From: MarkHobbs [REDACTED]
Sent: 08 November 2021 10:18
To: Paul Cann
Cc: Glynn Curtis; Sarah Burrow
Subject: RE: Little Sefter Extension, Pagham, Bognor Regis - OWC Application
Attachments: Barfoot - Sefter Barn FC2846.02E SW Drainage.pdf; Barfoot - Sefter Barn FC2846.03E Ext Levels & CF.pdf

From: Paul Cann <Paul.Cann@arun.gov.uk>
Sent: 28 October 2021 12:33
To: MarkHobbs [REDACTED]
Cc: Glynn Curtis [REDACTED] Sarah Burrow <Sarah.Burrow@arun.gov.uk>
Subject: RE: Little Sefter Extension, Pagham, Bognor Regis - OWC Application

External Levels (1:150)

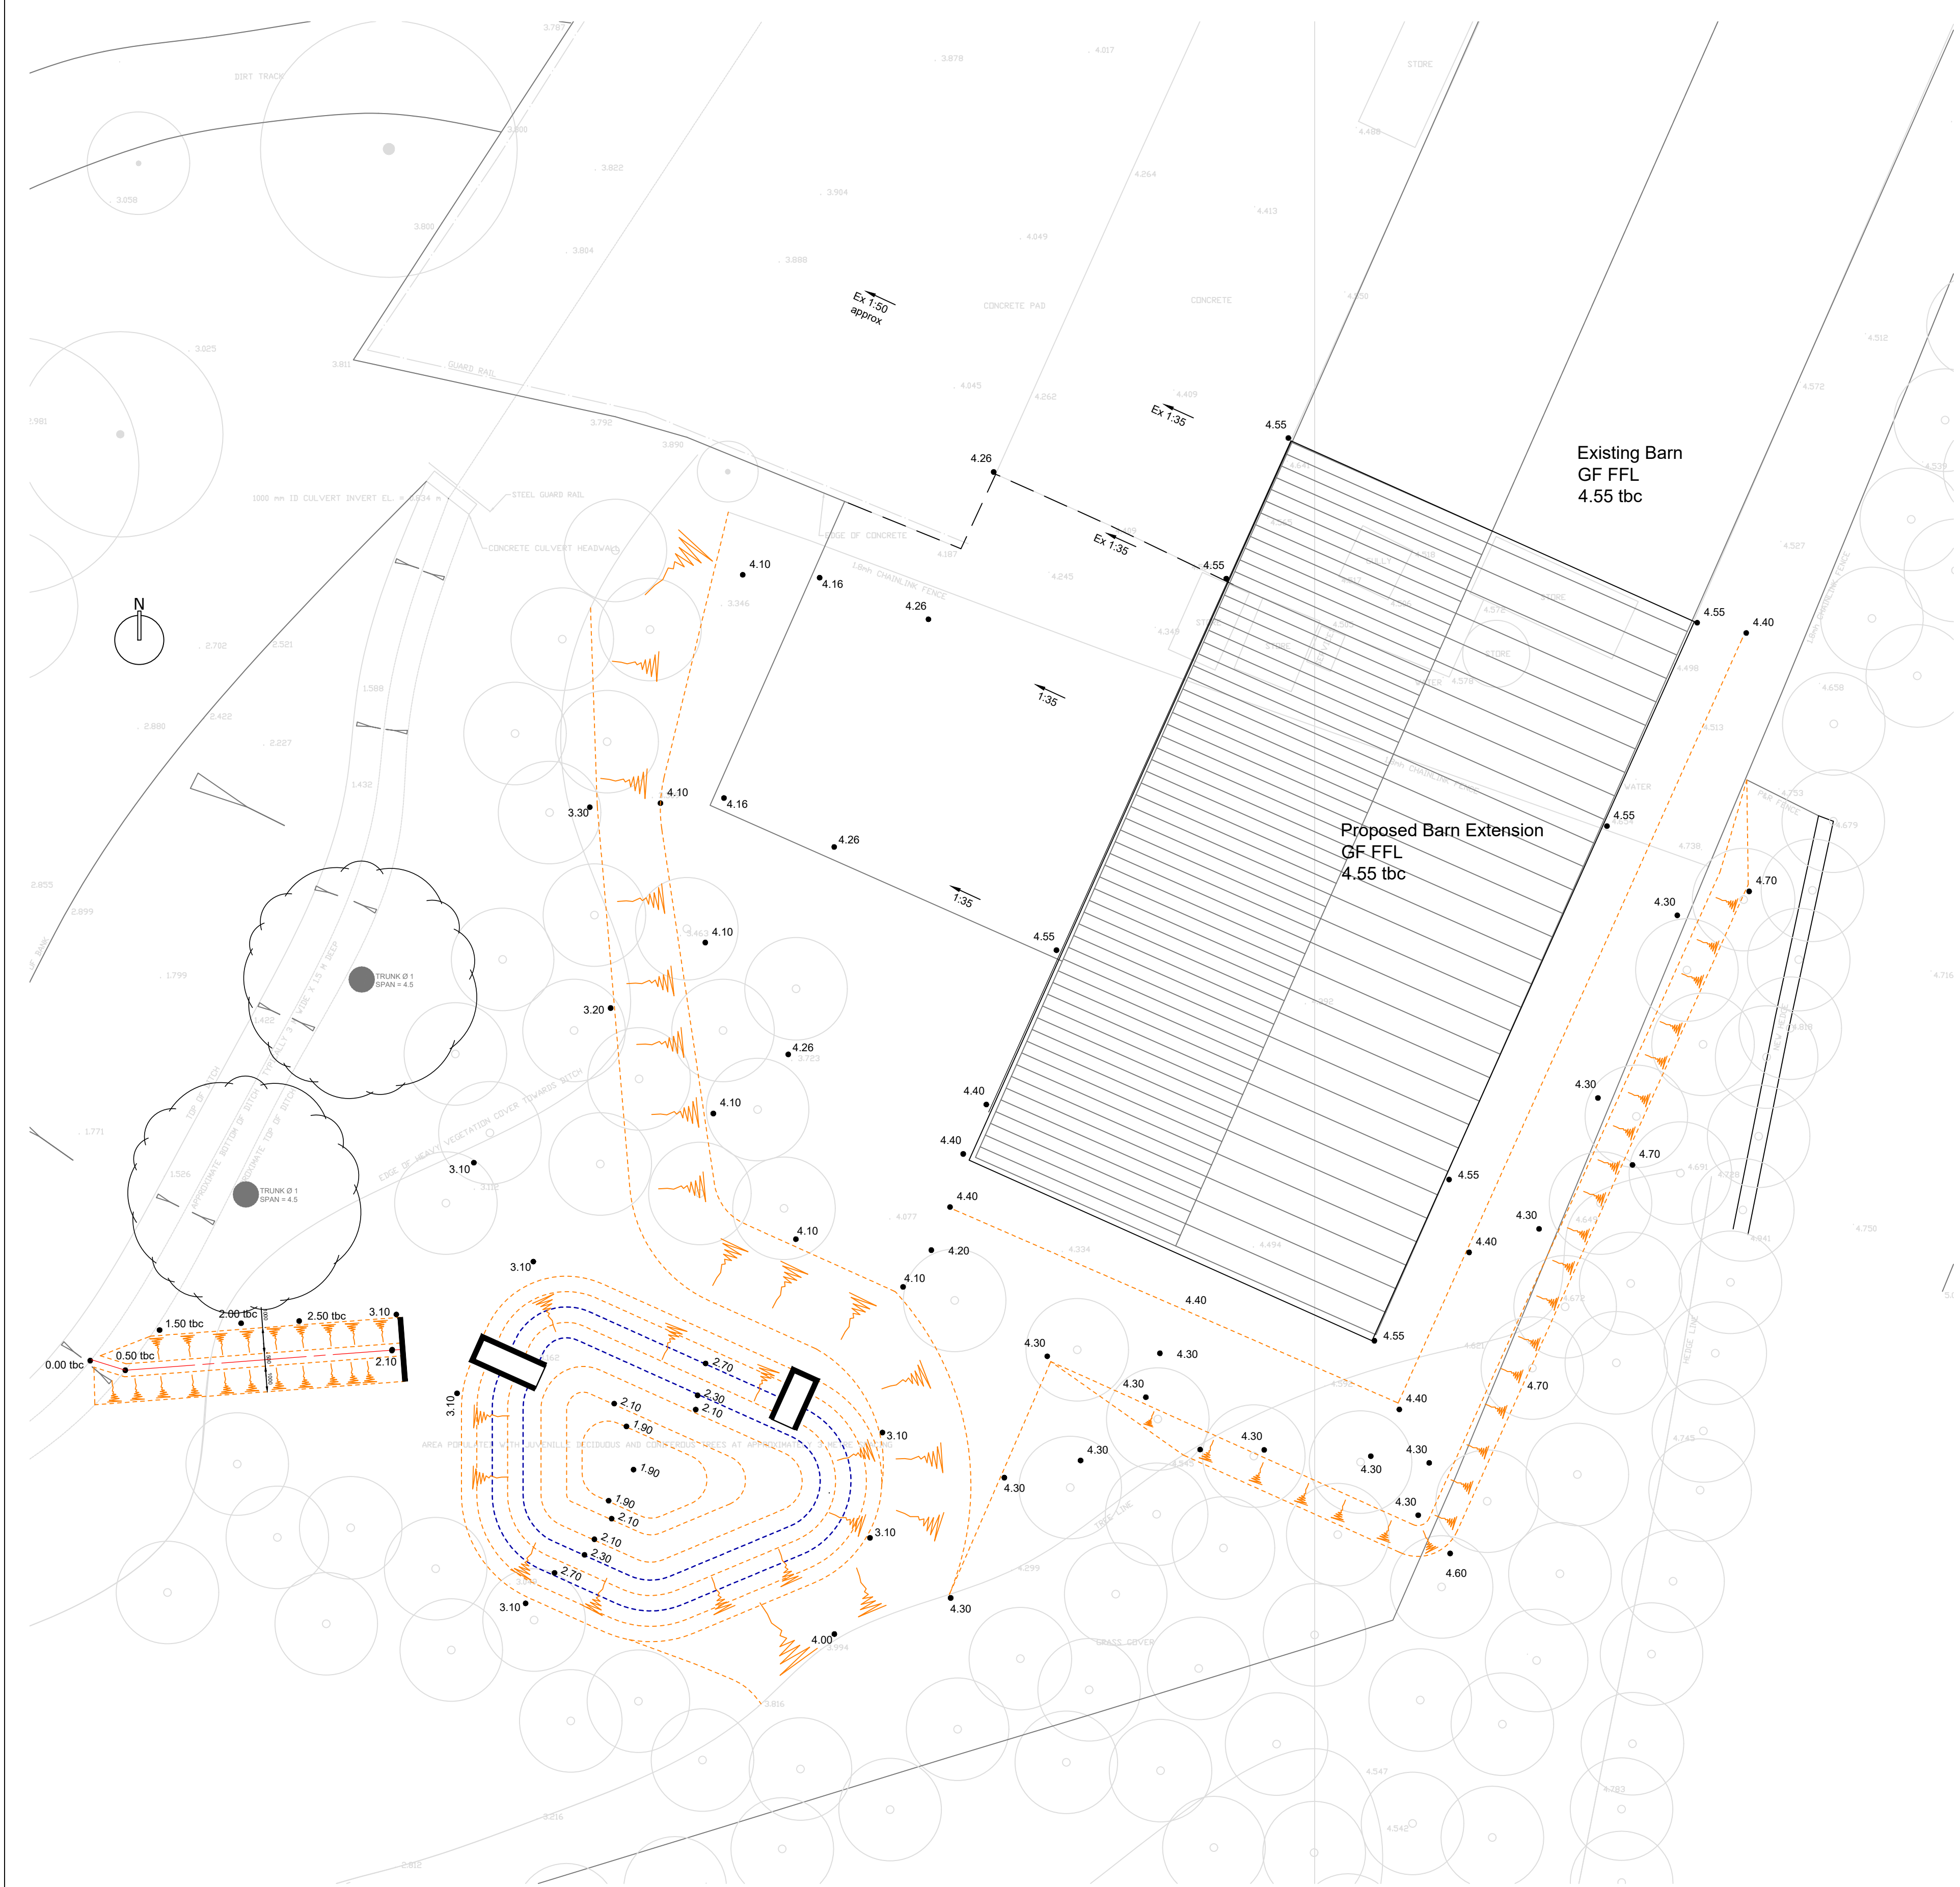
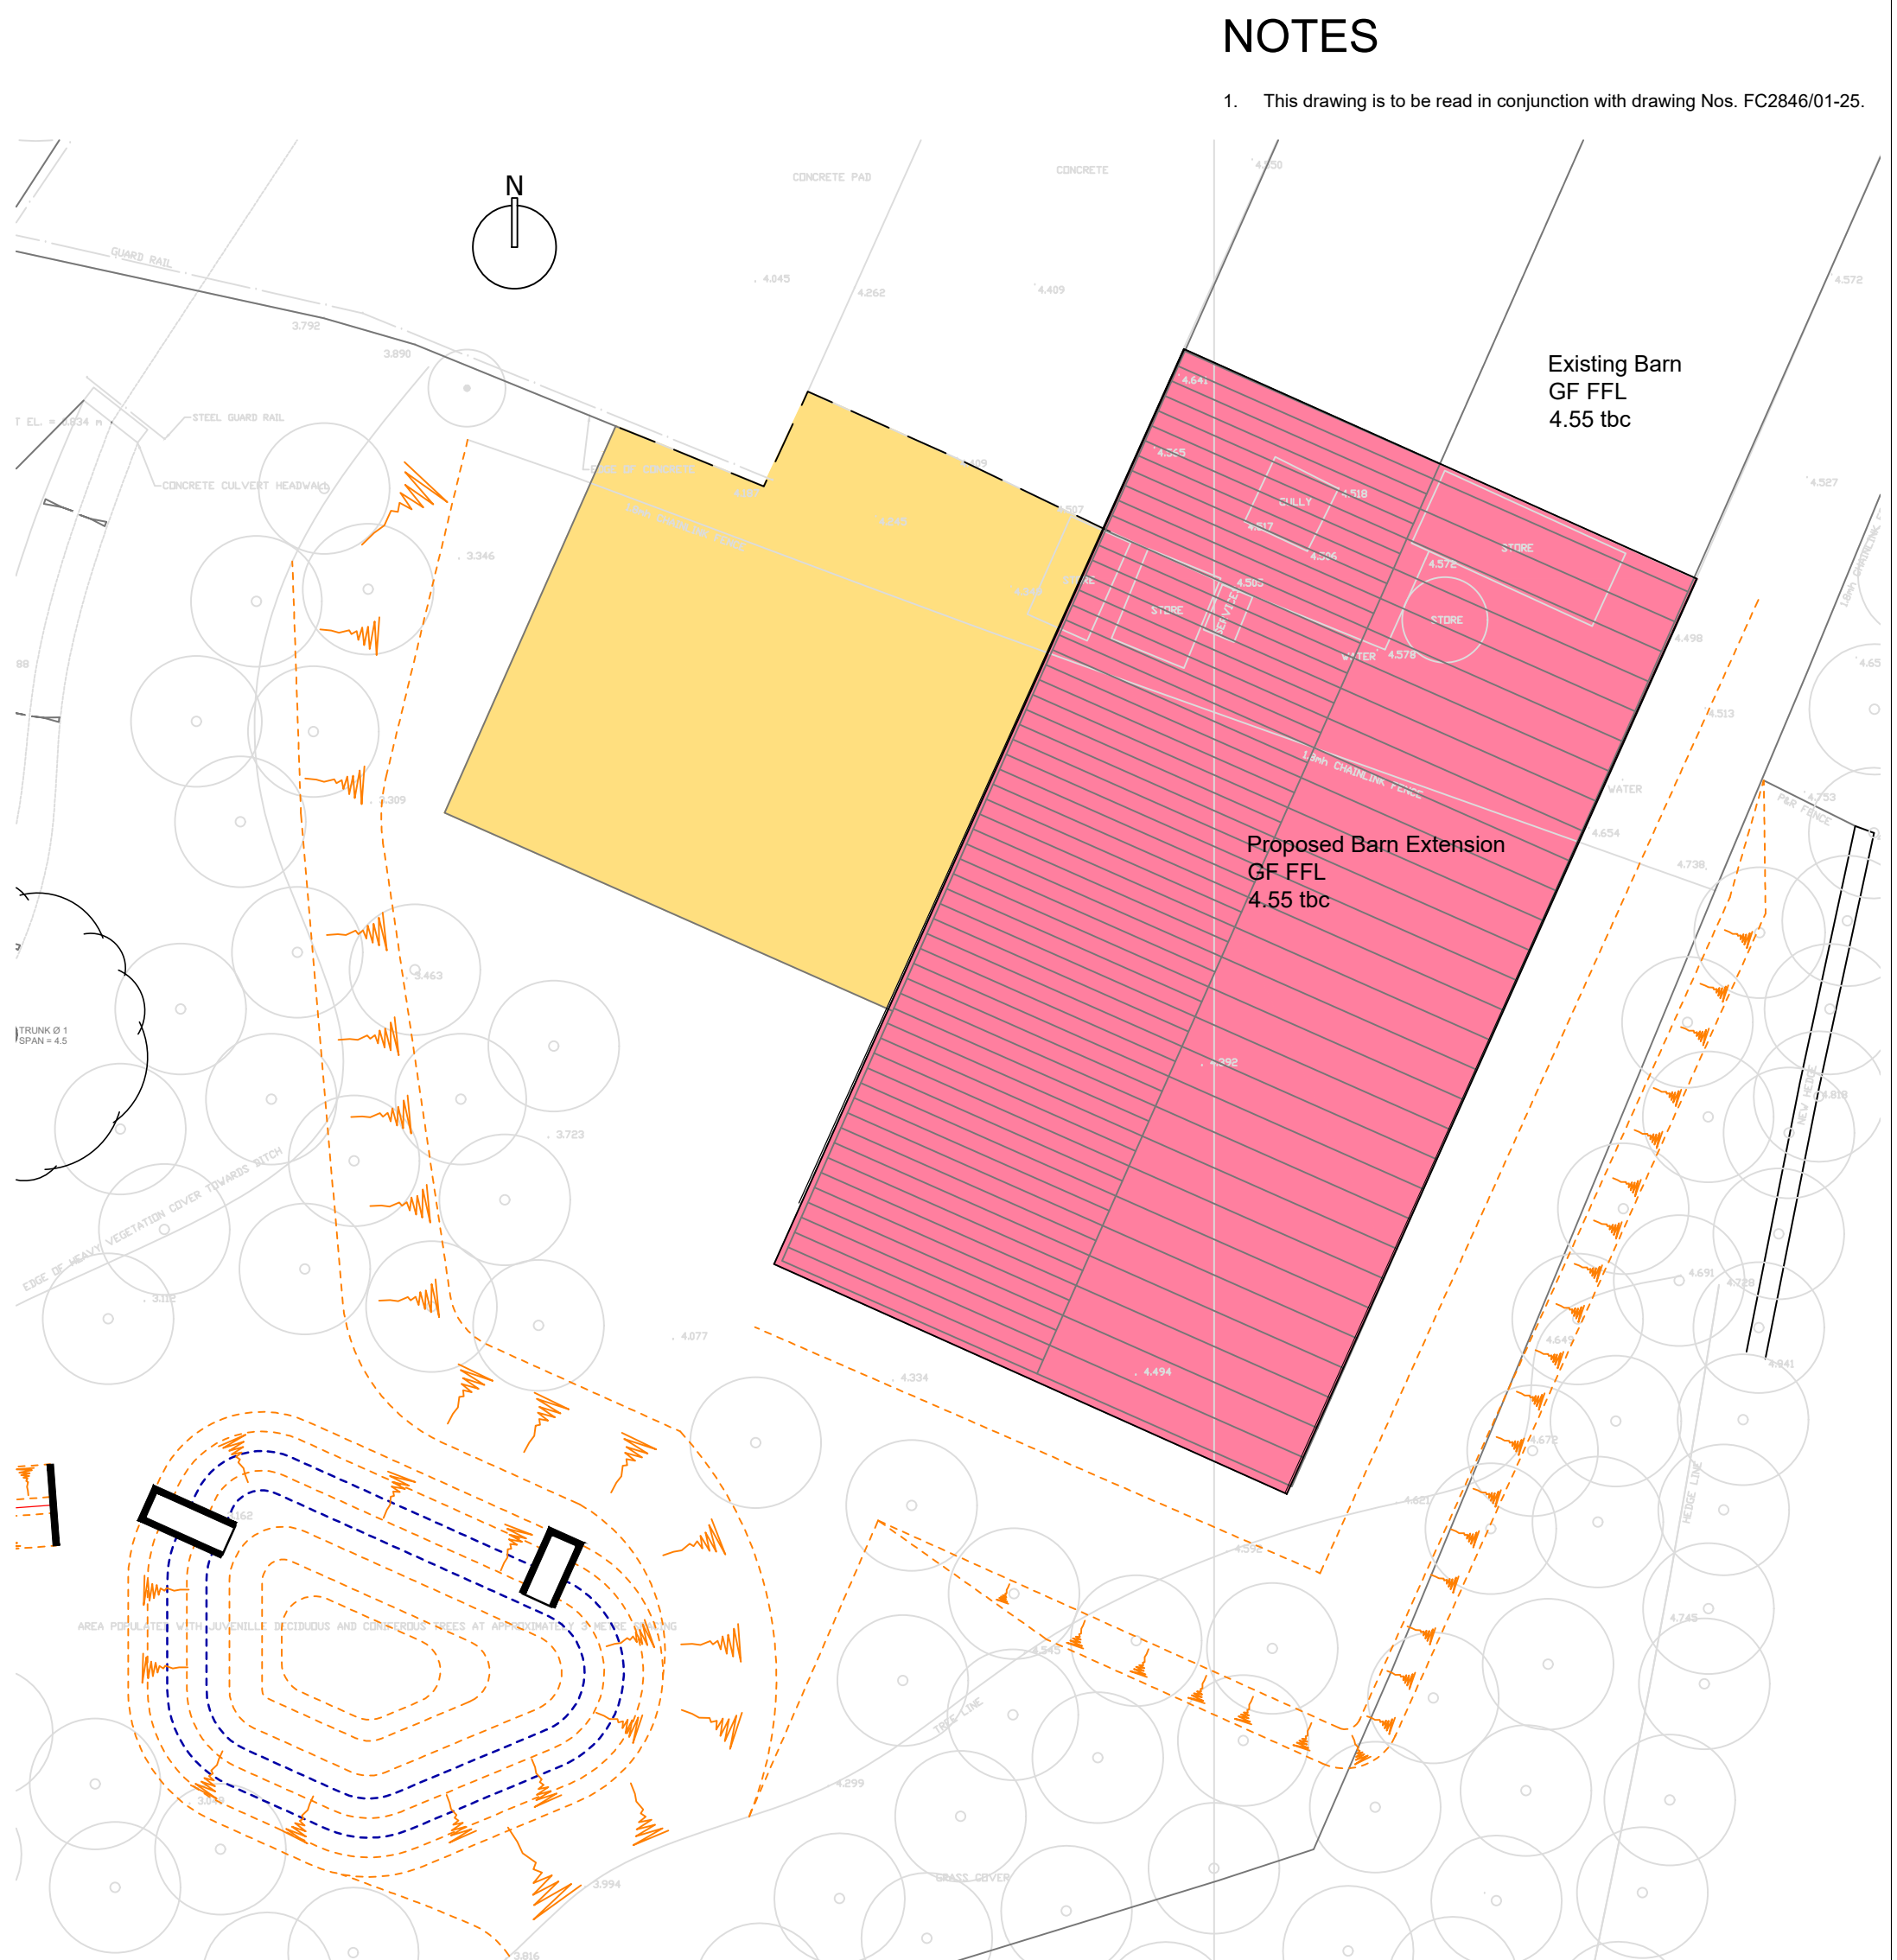
2. I note that important levels ie. existing ditch bed, new channel bed, etc, at still to be confirmed. We need to verify/confirm these levels at this stage.

Topo survey shows that the existing ditch is 1.5m deep. Top of bank was only recorded on one side due to existing dense vegetation, but top of bank is fairly consistent @ approx. 1.4–1.5m AOD in our area of interest. See attached topo. This would suggest the base of the existing ditch is circa 0.00m – which is what we have noted on our drawings to date, and we wouldn't expect it to be widely different from this. Given that the outfall from the flow control is at 2.3m we have a significant leeway to enable a connection to the ditch so do not think that levels are an issue in this location. Trust that you are happy with the data/assumptions shown on drawings without any further survey work being required Agree & ok
